Planning Officer: Ms M Tomalova

Planning Application Ref: AL/66/21/PL

Location: Land Rear (South) of Sundown, Littleheath Road, Aldingbourne, BN18 0SR

Description of works: 1 No. 4 bedroom detached dwelling with a detached 3 bay garage (2 open bays and 1 enclosed), associated foul field drain, storm soakaway, new front boundary treatment, roof mounted PV & Ground Source Heat pump System (resubmission following AL/62/19/PL). This site is in CIL Zone 3 and is CIL Liable as new dwelling

DRAWING TITLE
Proposed Site Plan
(Incl Location Block Plan)

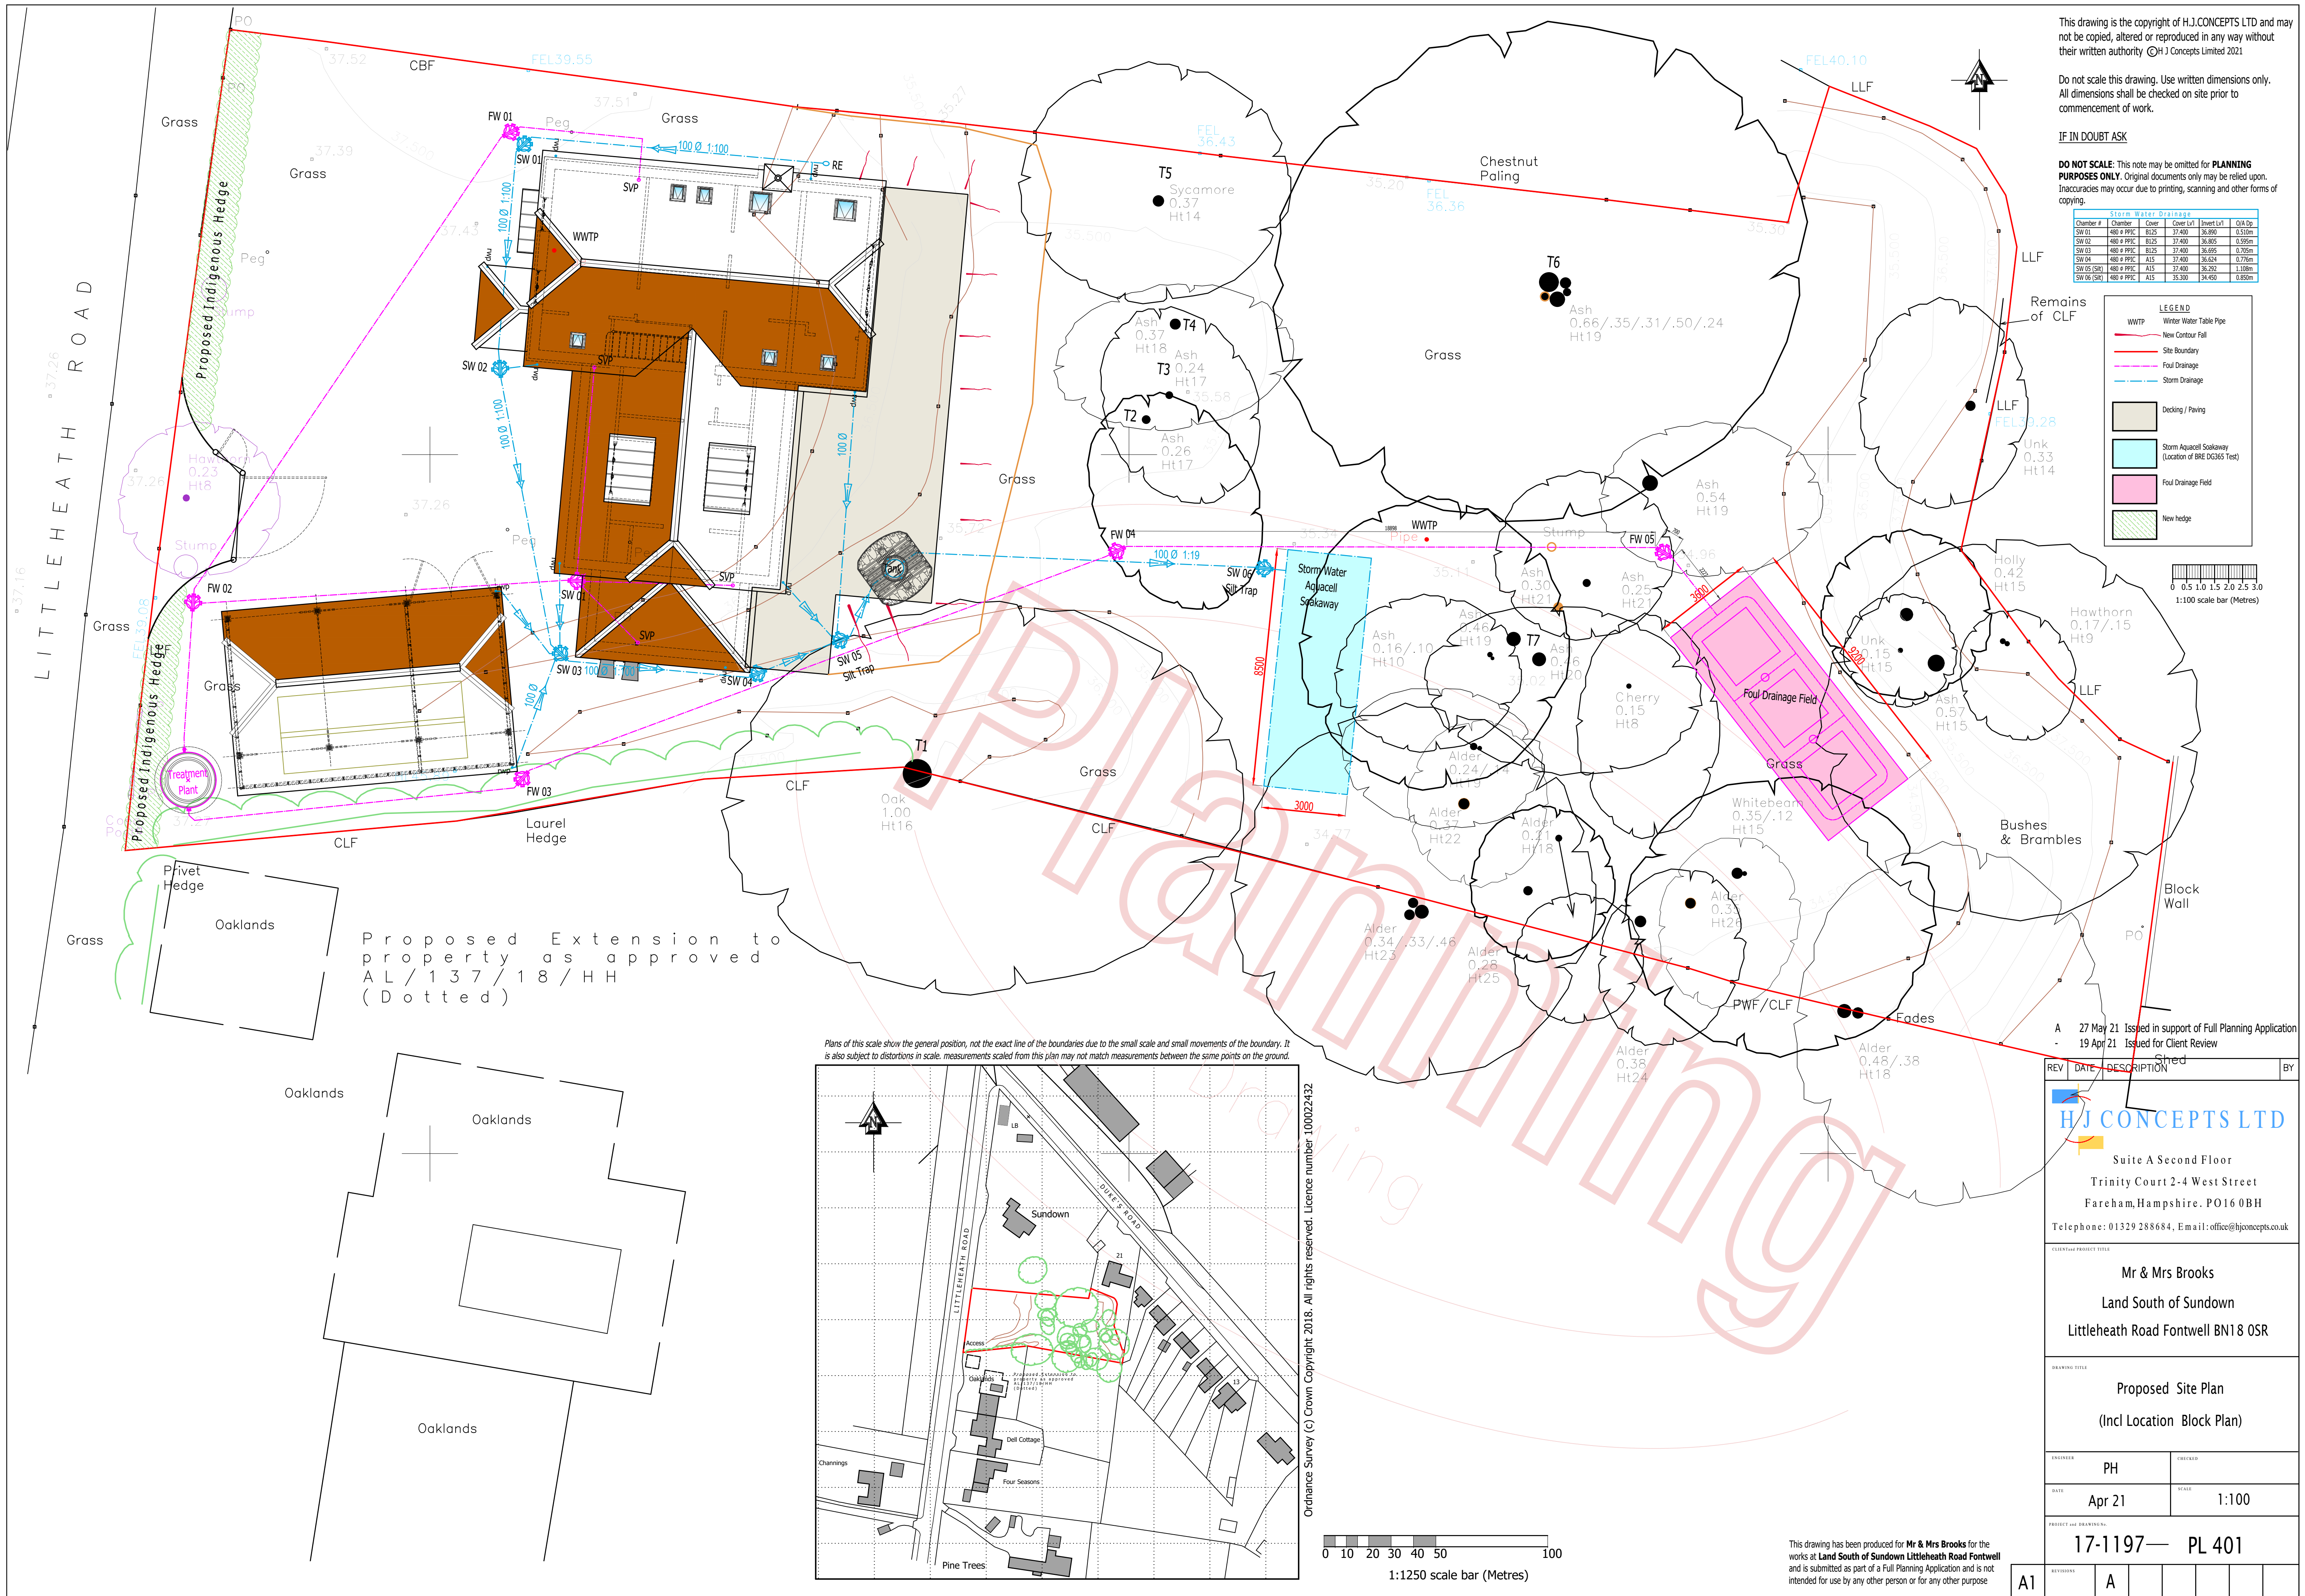
- The Tree Protection Plan fails to adequately illustrate the relationship between tree root protection areas and development proposals. Whilst accurate data and interpretation may have occurred, we cannot adequately appreciate the impact on trees from this style of illustration. Ideally, we need to see the RPAs/Block plan/Drainage proposals overlaid, to understand the relationship between and viability of each element.

- There does not appear to be an overriding justification for the siting of a dwelling within the RPA of Oak (T1). Furthermore, the installation of subterranean utility apparatus using conventional methods of construction carries a high risk of damage to what appears on paper to be the most valuable tree on site. Notwithstanding the proposed level of supervision during trench excavation and results (unsubstantiated) of exploratory root investigations, there is ambition that larger roots will be

appropriately retained. Such a proposal might incur a *fait accompli* for the tree in the event substantial root material is encountered within the area of excavation – with damage resulting and potential decline. I find this unjustified level of risk unacceptable and recommend that element of drainage strategy be abandoned.

- There is neither an approved or apparently even a supportable surface water drainage (and foul water sewer) strategy for the site. Those fundamental elements of the scheme ought to be addressed to our satisfaction in association with layout proposals, so that we are not subsequently held hostage to flood mitigation measures which could then impact heavily on retained trees, hedgerow and landscape plans.
- I draw attention to the nominal root protection areas (RPA) of retained trees and their growth potential as obvious constraints to the introduction of subterranean utility apparatus. The provision of appropriate buffer/easement around such features must also take into account that growth potential (roots), to limit the risk of damage occurring during future maintenance of the same, from compaction/contamination of the soil structure.
